RE: 25 SEA WAY, MIDDLETON-ON-SEA

PLANNING APPLICATION M/41/18/HH

25 SEA WAY, MIDDLETON-ON-SEA PLANNING APPLICATION M/41/18/HH

I write as Chairman of the Middleton-on-Sea Association, ("MOSA") which represents approximately 250 households within the Middleton-on-Sea Area of Special Character, with regard to the development proposed in Planning Application M/41/18/HH.

PROPOSED ELEVATIONS

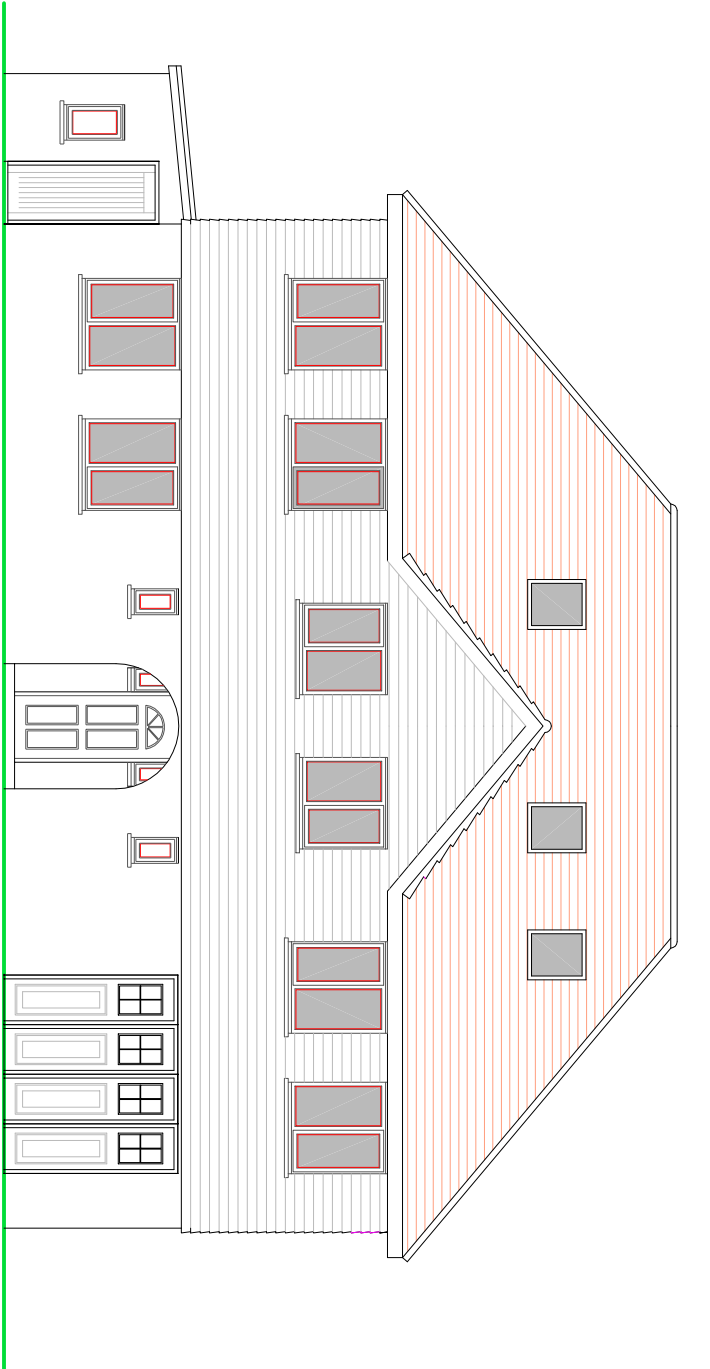
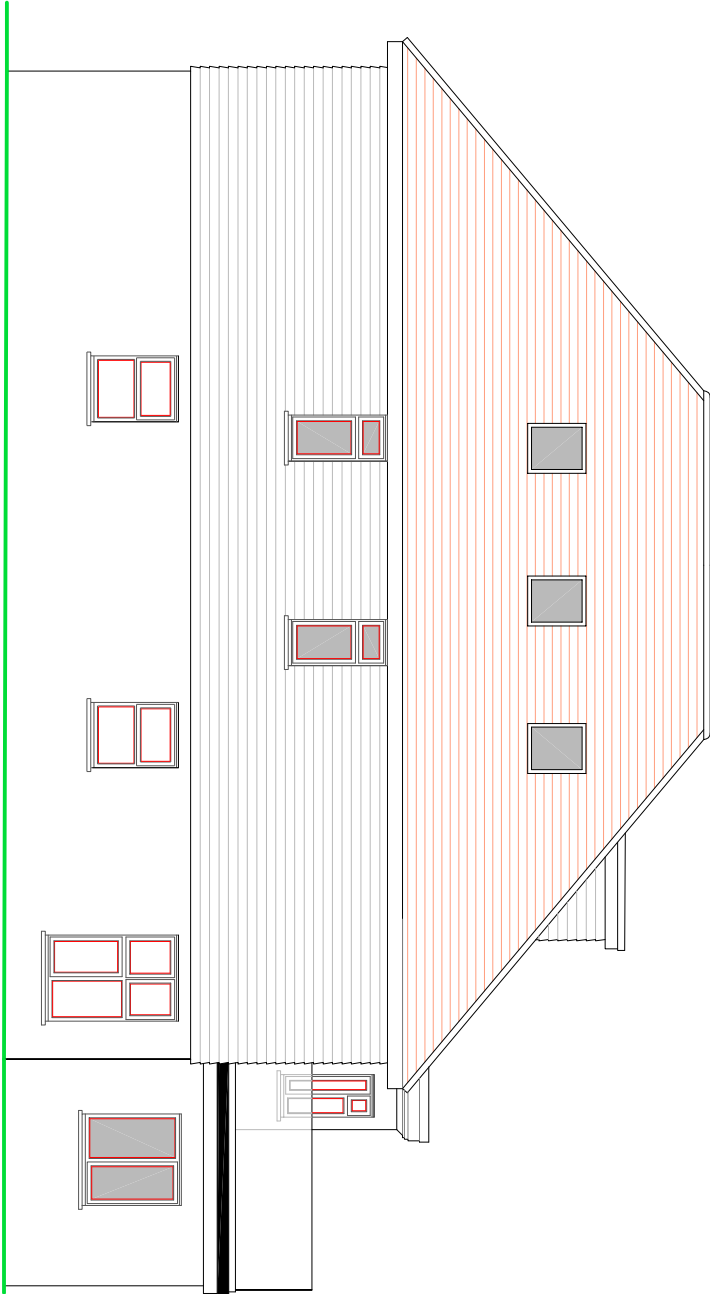
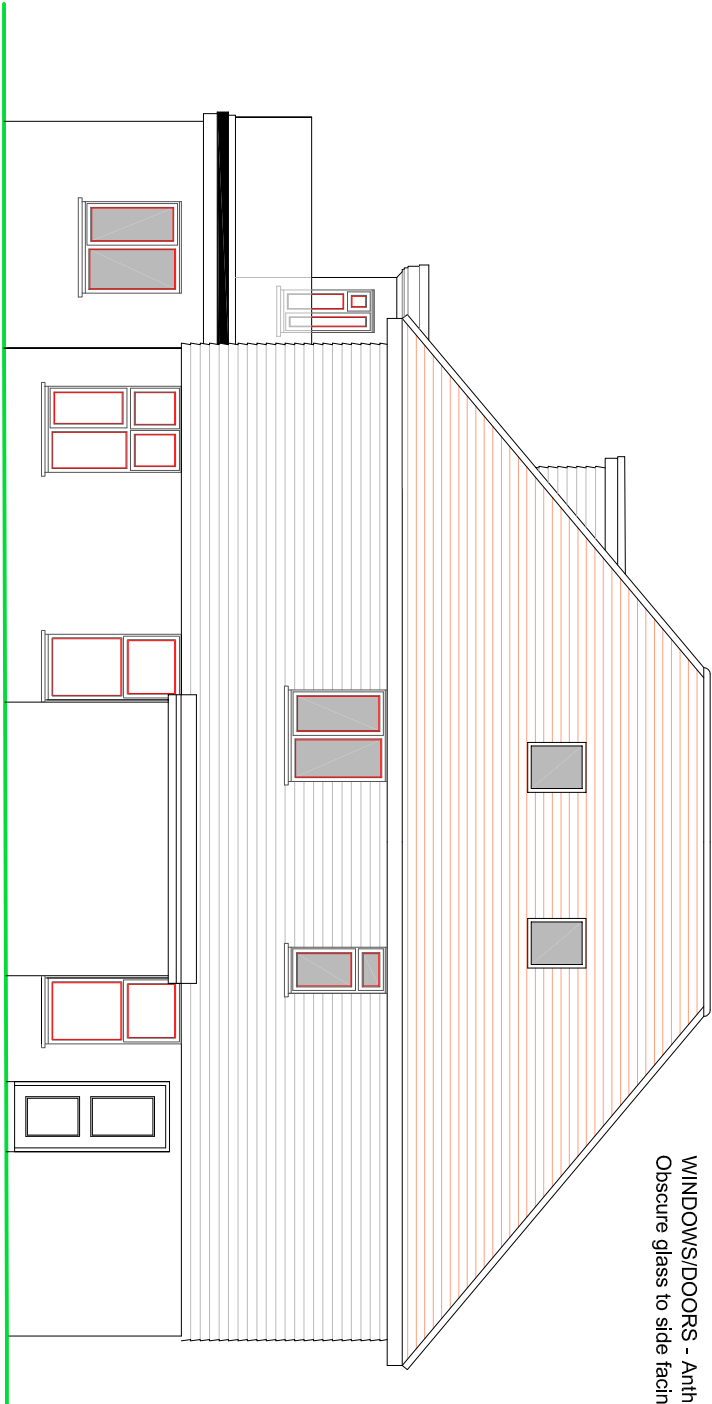
We believe that the proposed development would adversely affect the Area of Special Character. Further, that it would be contrary to explicit supplementary planning guidance in the Village Design Statement. It would amount to an overdevelopment of the site as the height and bulk would compromise the spacious layout of the area. It would amount to an unneighbourly development

It would be out of keeping and out of character with the street scene. Indeed, it would be out of character and out of keeping with all other properties in the Area of Special Character. It would be the only detached dwelling on this estate with a balcony and sun terrace at third floor level.

The proposed development would be overbearing, would overshadow and give rise to an unacceptable level of overlooking of neighbouring properties which would be prejudicial to the privacy enjoyed by neighbouring properties.

REAR ELEVATION

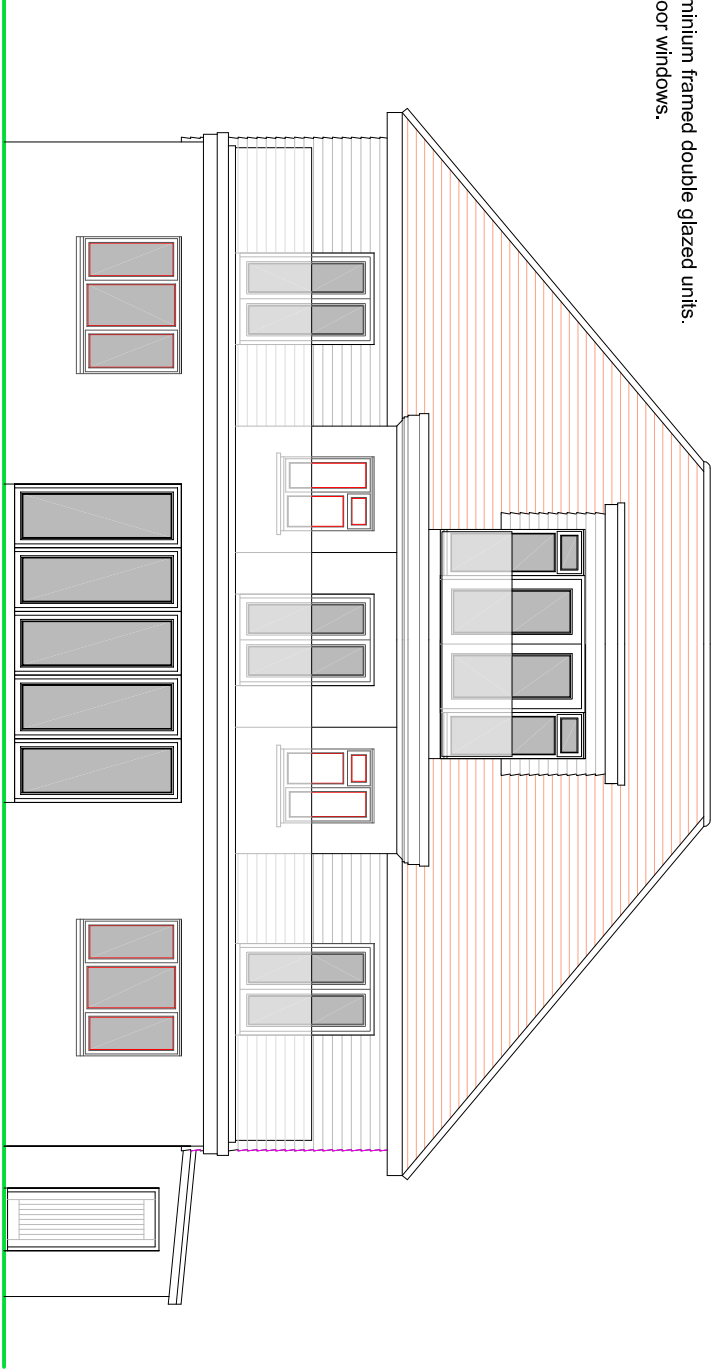
Effectively, the property becomes three storeys – three floors – with the third floor readily apparent in drawings of the rear (south) elevation.
